REPORT UPDATE

Application No: Y/93/14/OUT

REF NO: Y/93/14/OUT

LOCATION: Land North of Yapton C of E Primary School
North End Road
Yapton

DRAWING NO YAP/DR/1

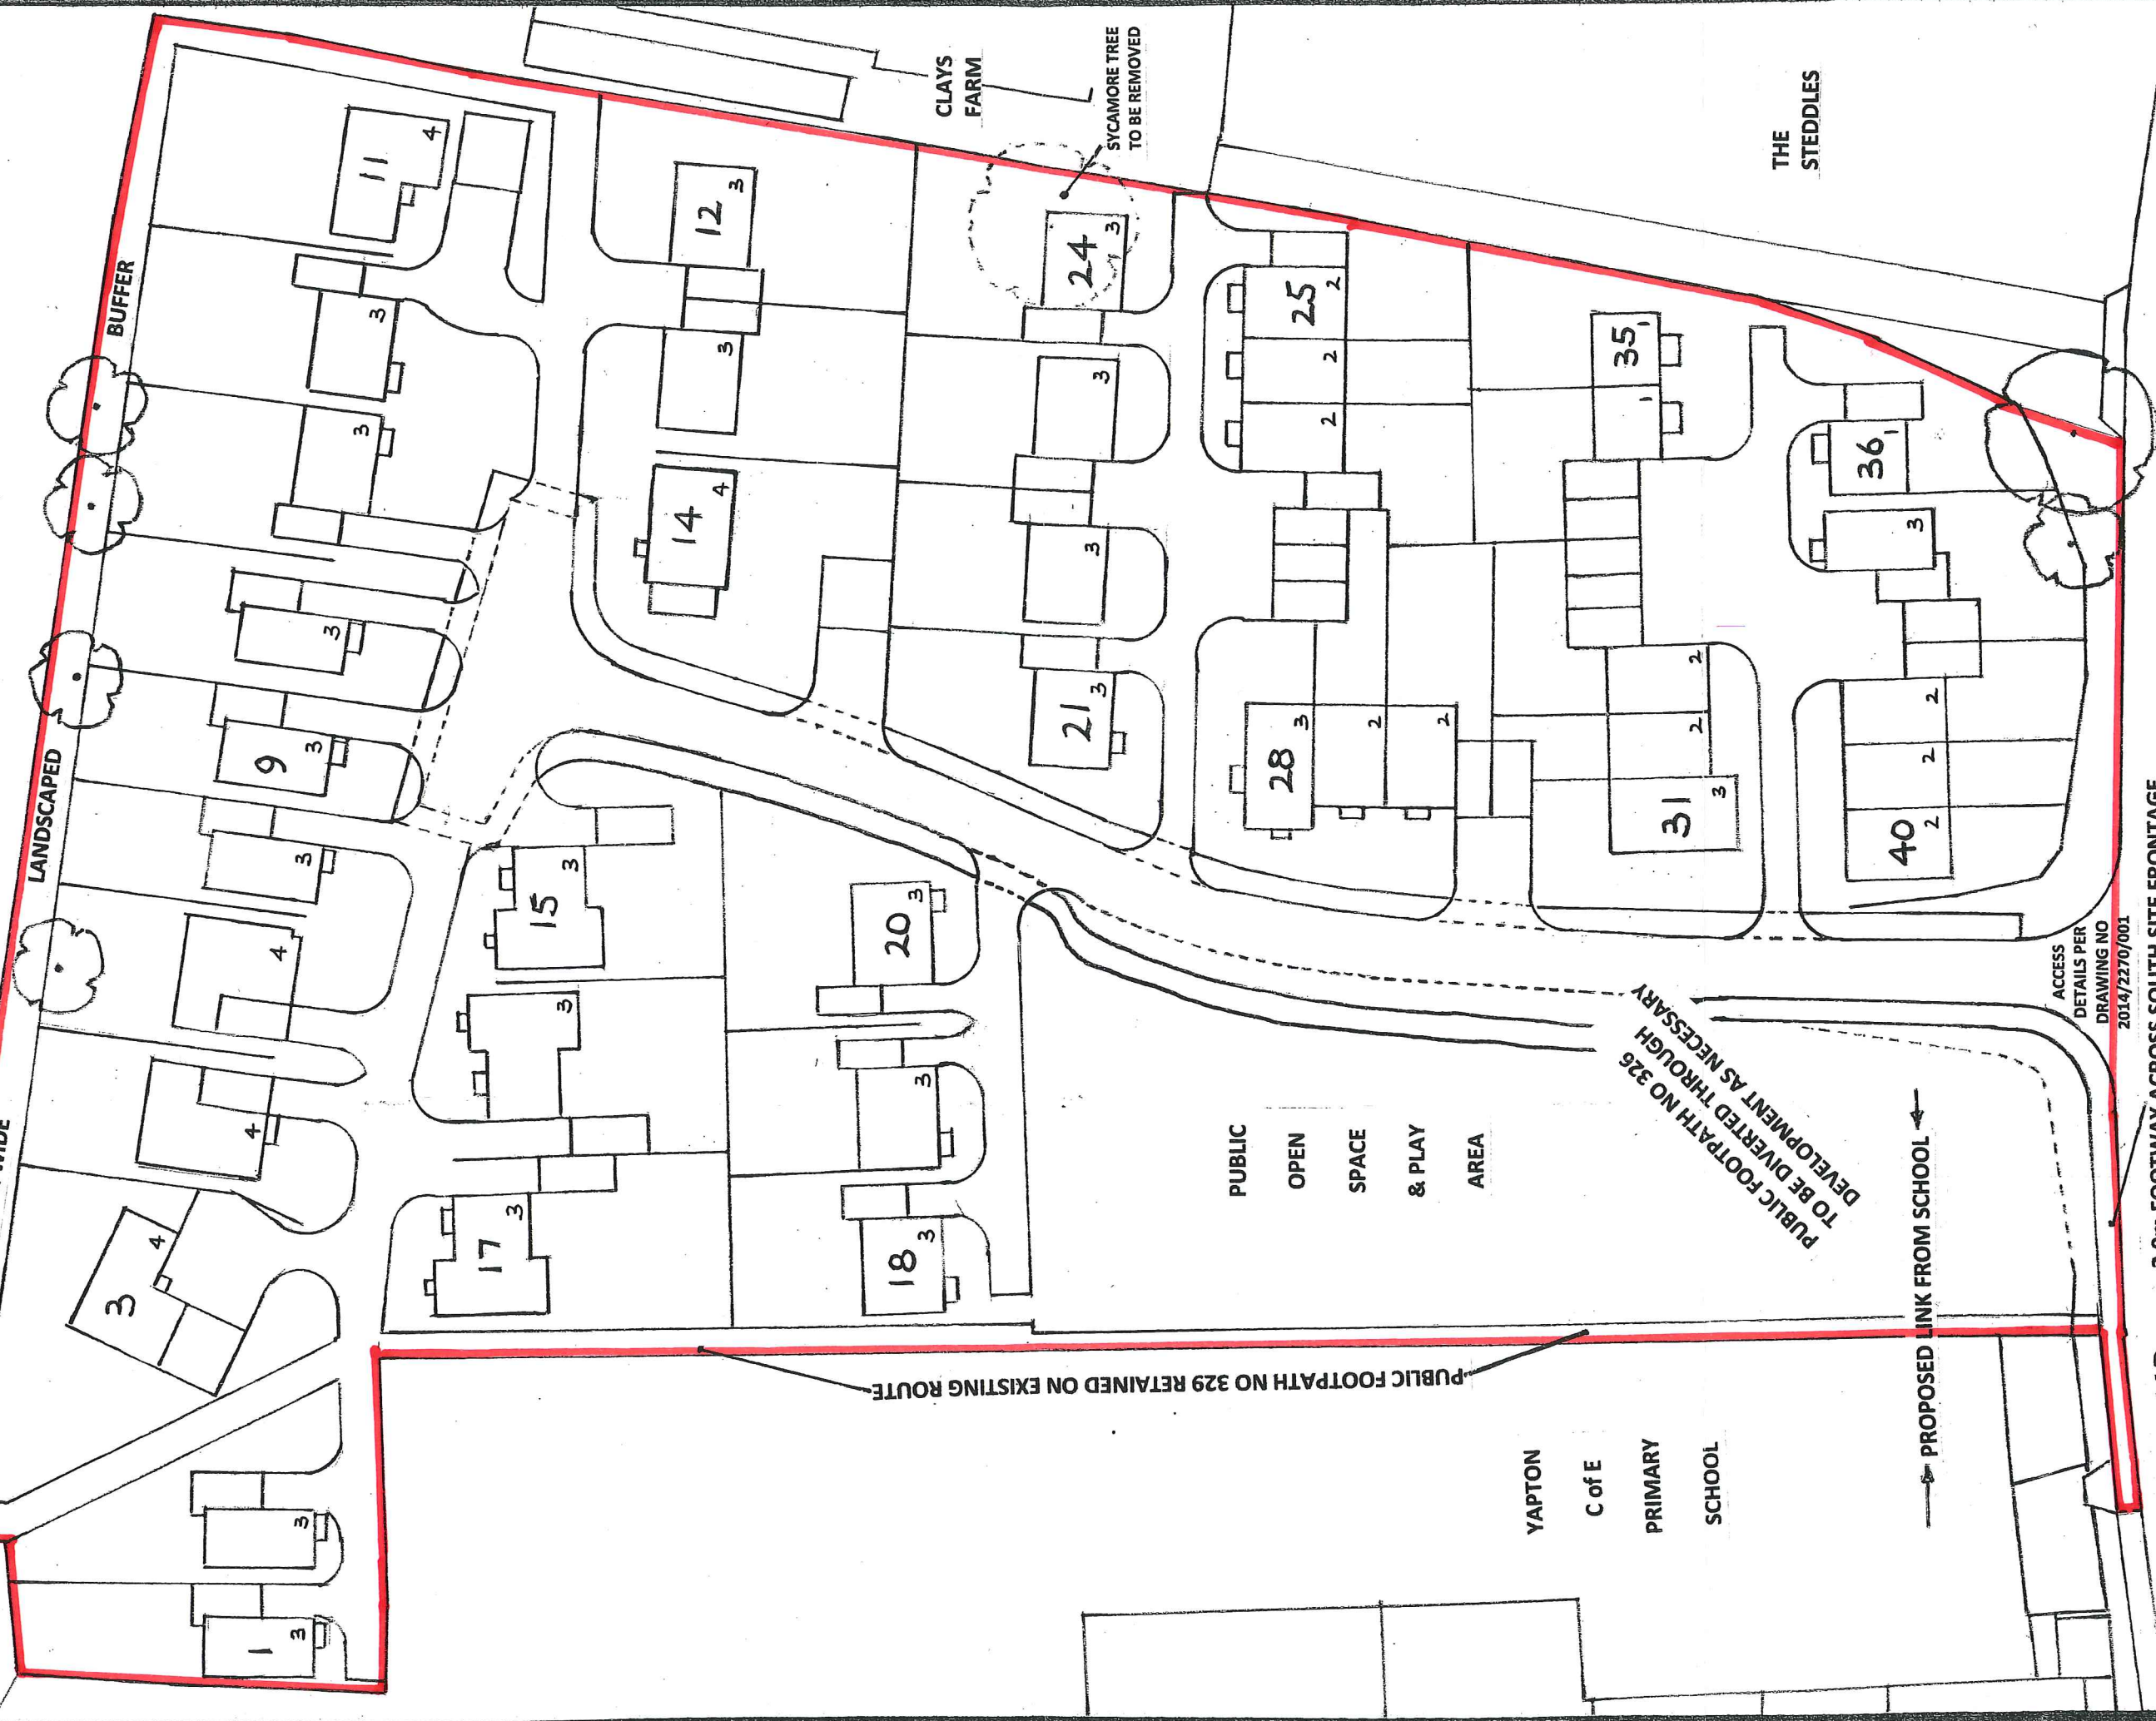
"I note that the dwellings have reduced from 40no down to 38no this would reduce the requirement for POS to 2,190m², it is unclear from the drawing what quantity is being provided, maybe clarification could be sought on this. I don't think that the POS being split is too much of an issue although it does require the users to cross the access road if wanting to utilise both areas. It is however located in the centre of the site which is potentially better positioning. Landscaping details could be reserved or conditioned."

The amount of POS provided is 0.234 hectares and therefore exceeds the actual requirement.

SYCAMORE TREE
TO BE REMOVED

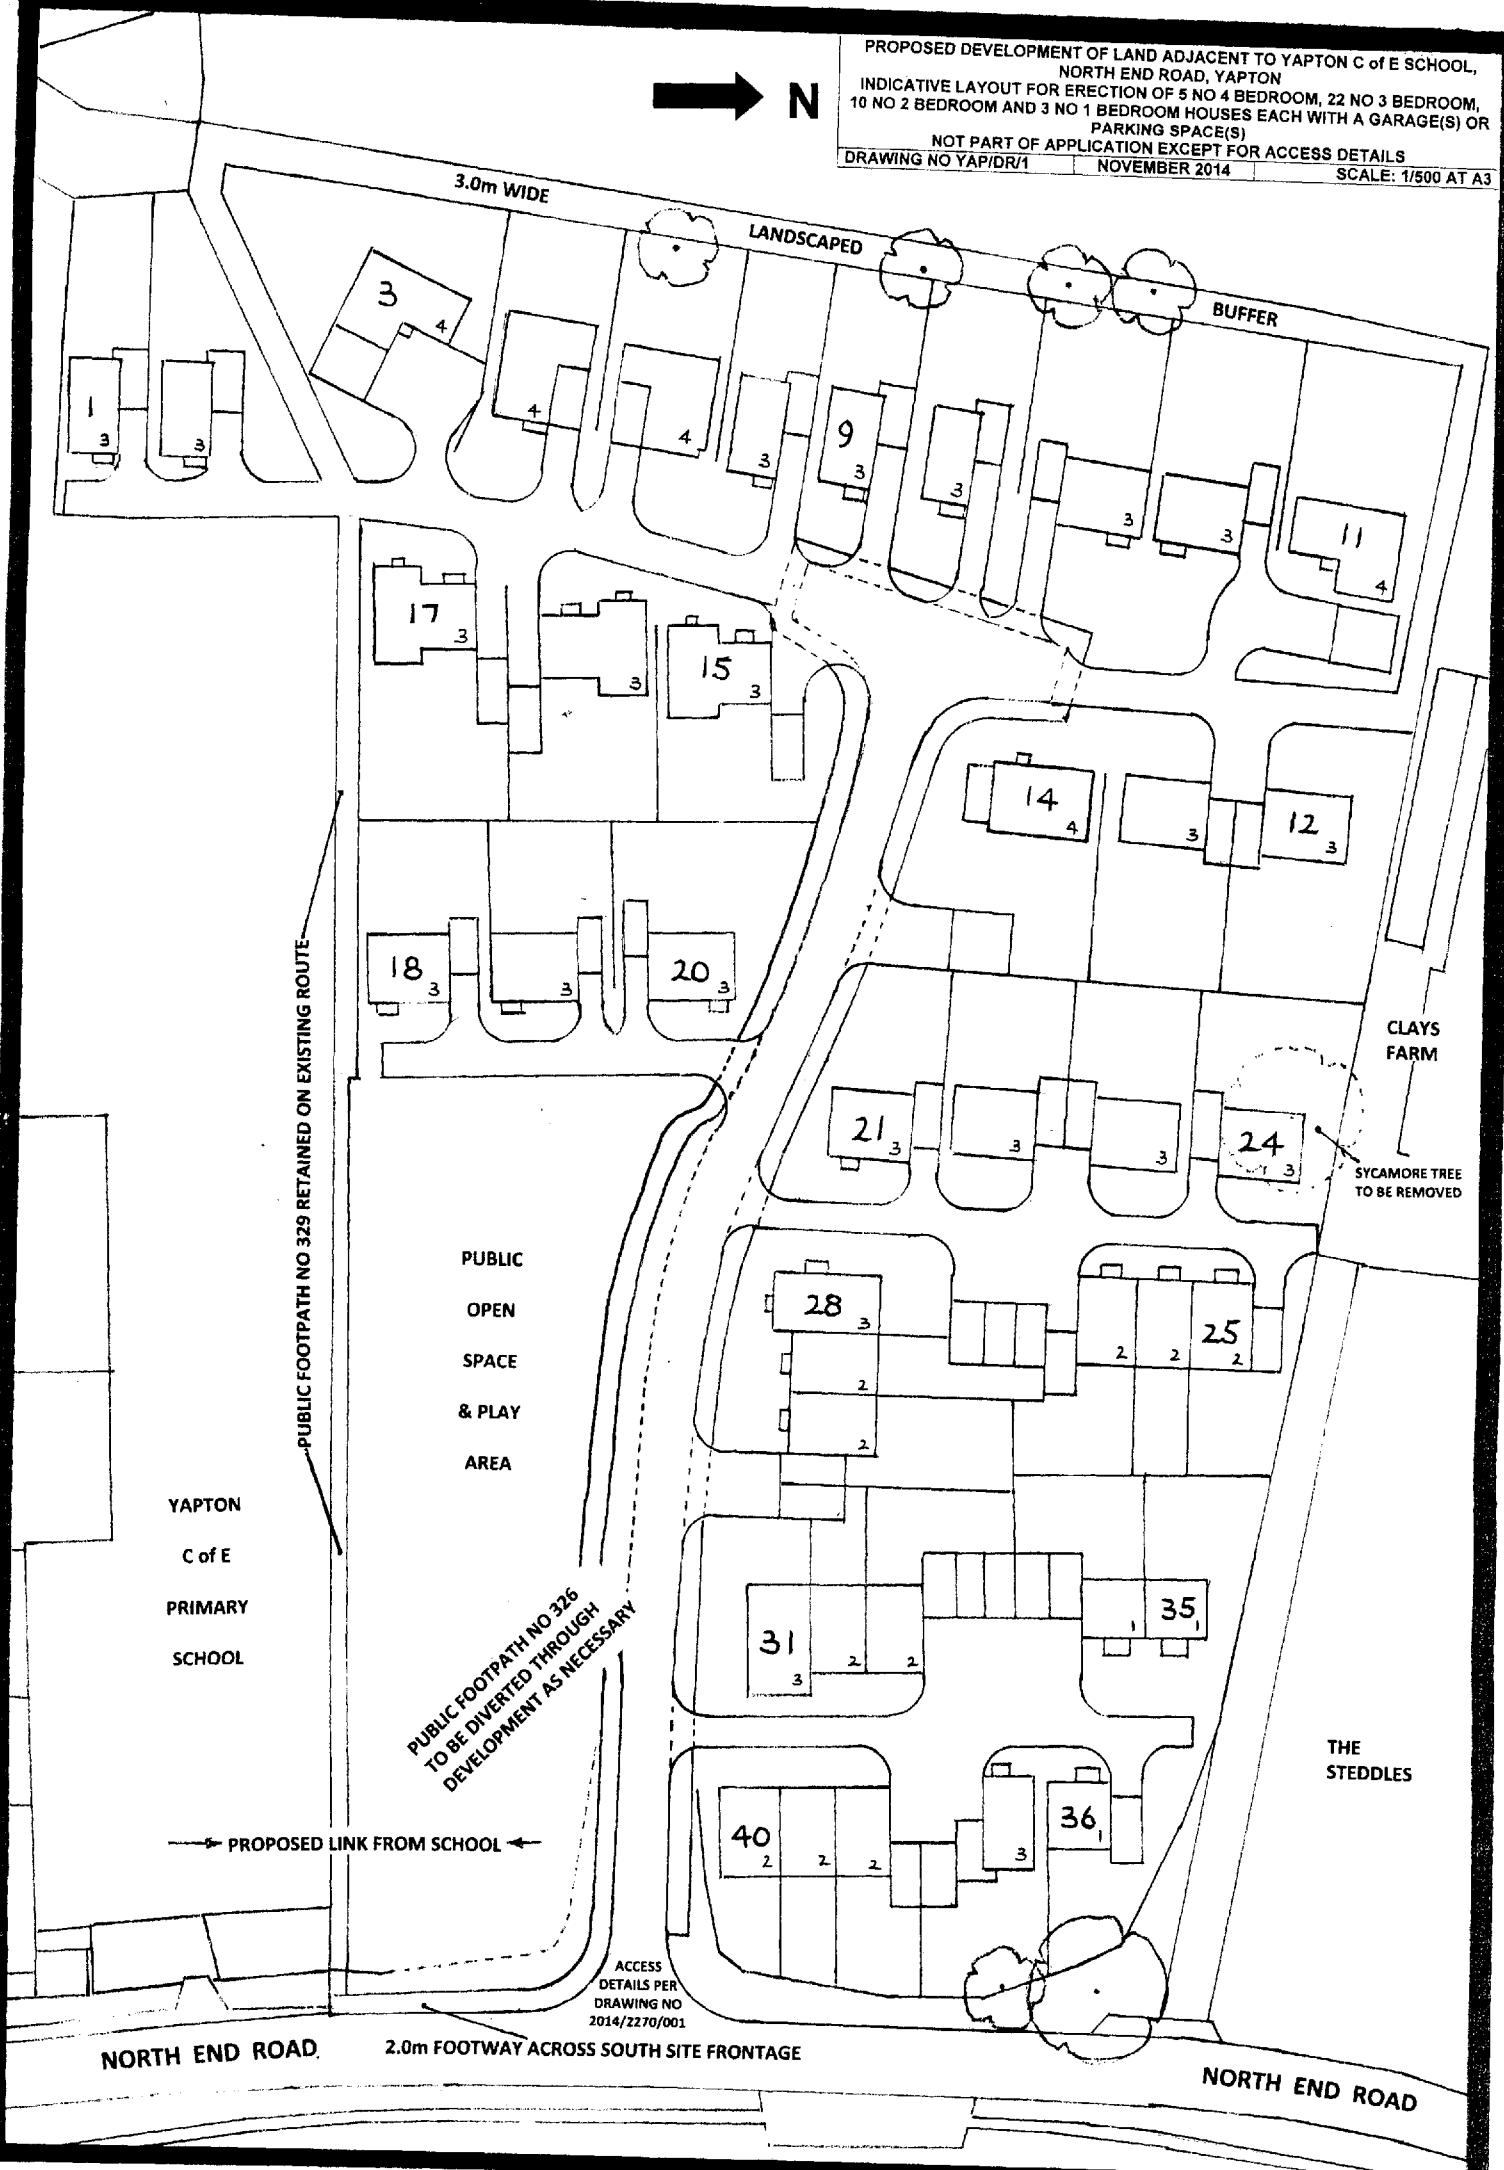
The agenda report states on three occasions that the development will result in the loss of a Sycamore Tree close to the northern boundary. This would have been the case but following amendments to the planning layout, the tree will now be retained. The occasions are as follows:

ADC Arboriculturist - Object to the application on the basis that no tree protection details have been submitted. Also commented on the Sycamore tree to be removed and states that a Tree Preservation Order on this tree would be defensible.

In respect of the Tree Preservation Order recommendation from the Council's Arboriculturist in respect of the Sycamore tree, it is noted that the Tree's tempo score of 13 falls within the range of "TPO defensible" (a score of 11-14) and not in the higher range for Definitely merits TPO

(15+). The tree itself is seen against a backdrop of other trees to the north of the site and it is therefore not considered that its loss would be significantly adverse to the amenity of the area.
